**Consultation Response from KC,
Trees**

2024/90253 Land at, Cuckstool Road, Denby Dale, Huddersfield, HD8 8RB

Outline application for erection of residential development with associated biodiversity and open space enhancements

Date Responded: 25/04/2024

## LANDSCAPE KEY

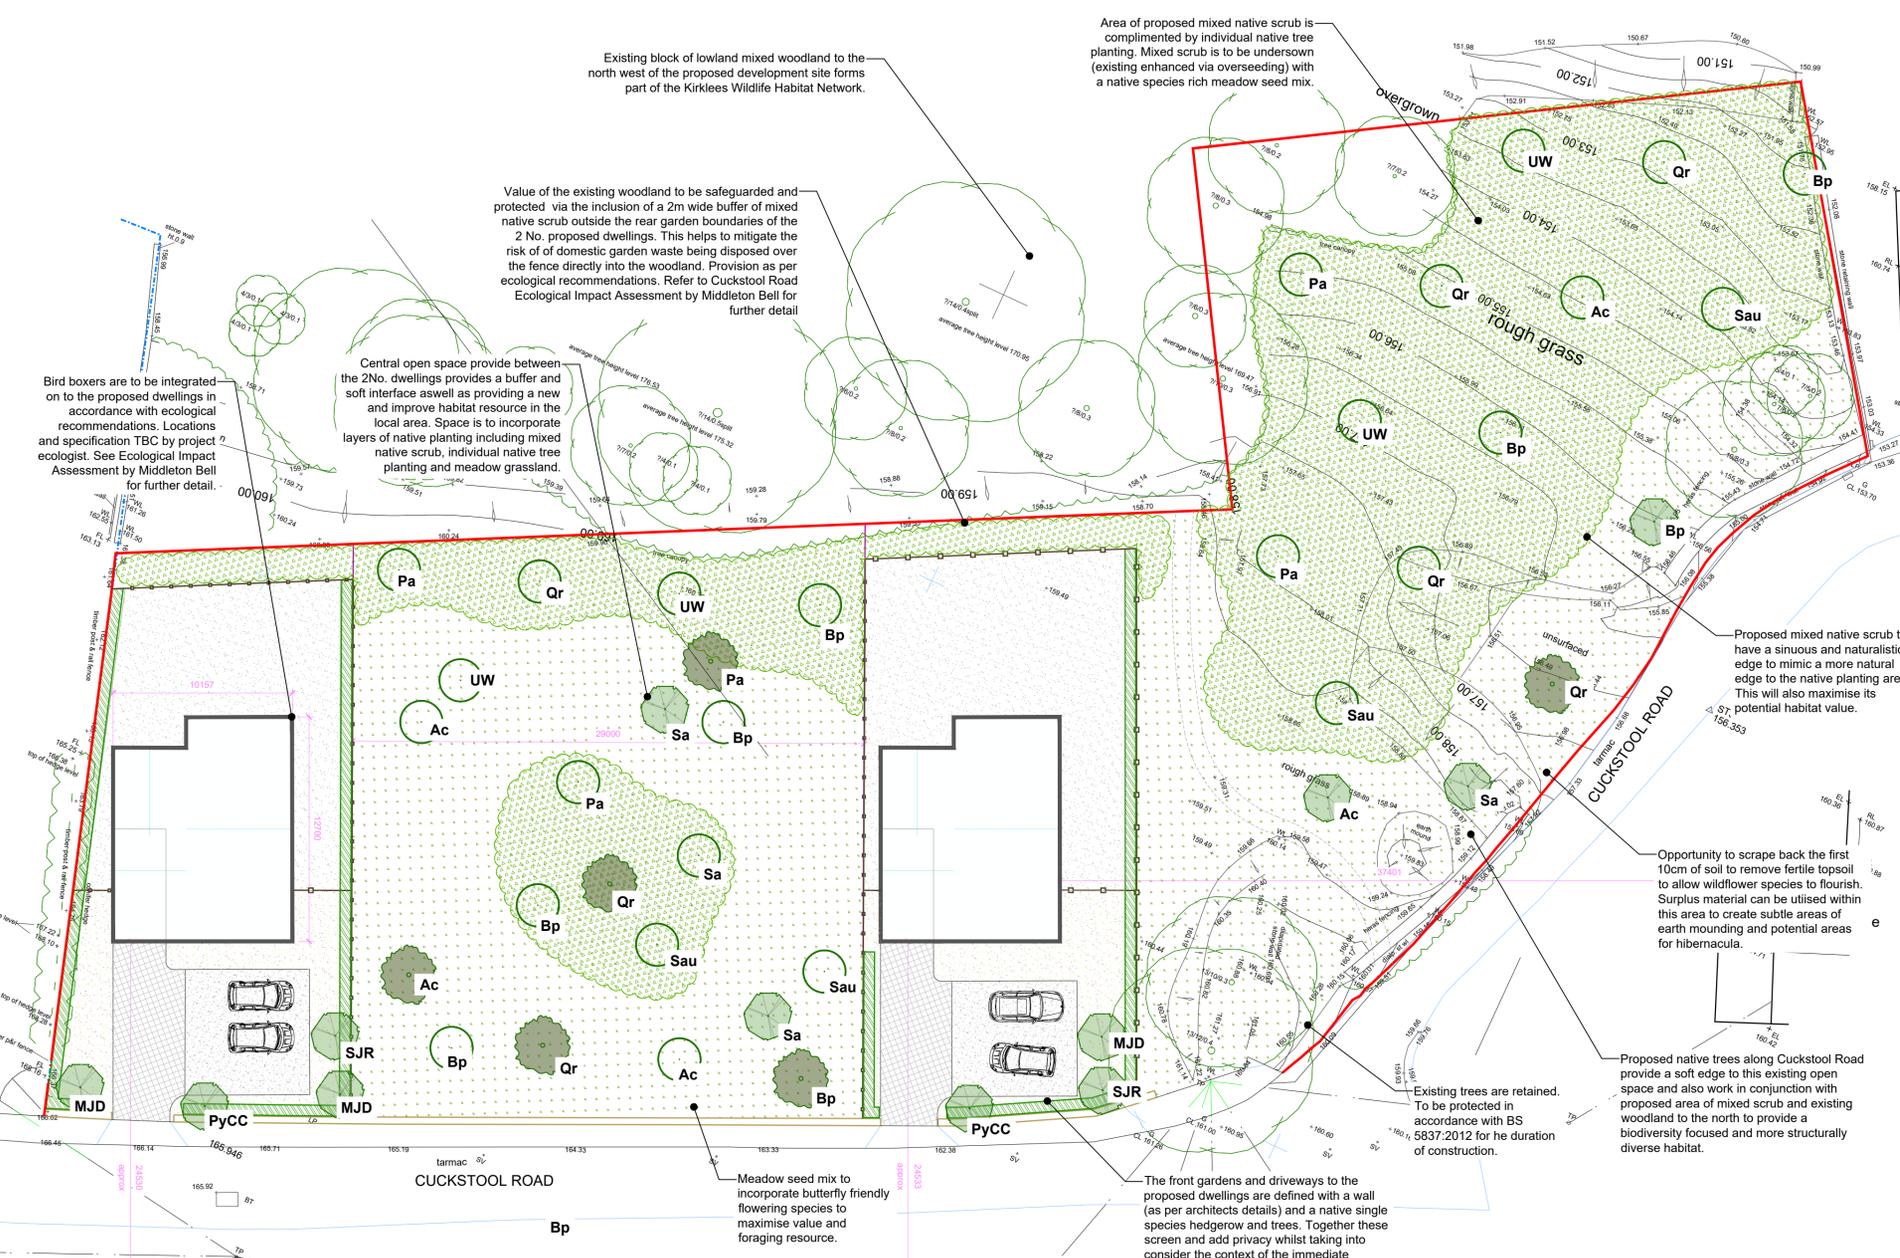
The proposed new planting and soft-landing, drawing PWP 811 001 Rev. 00 looks good from a KC trees perspective and provides a good level of detail.
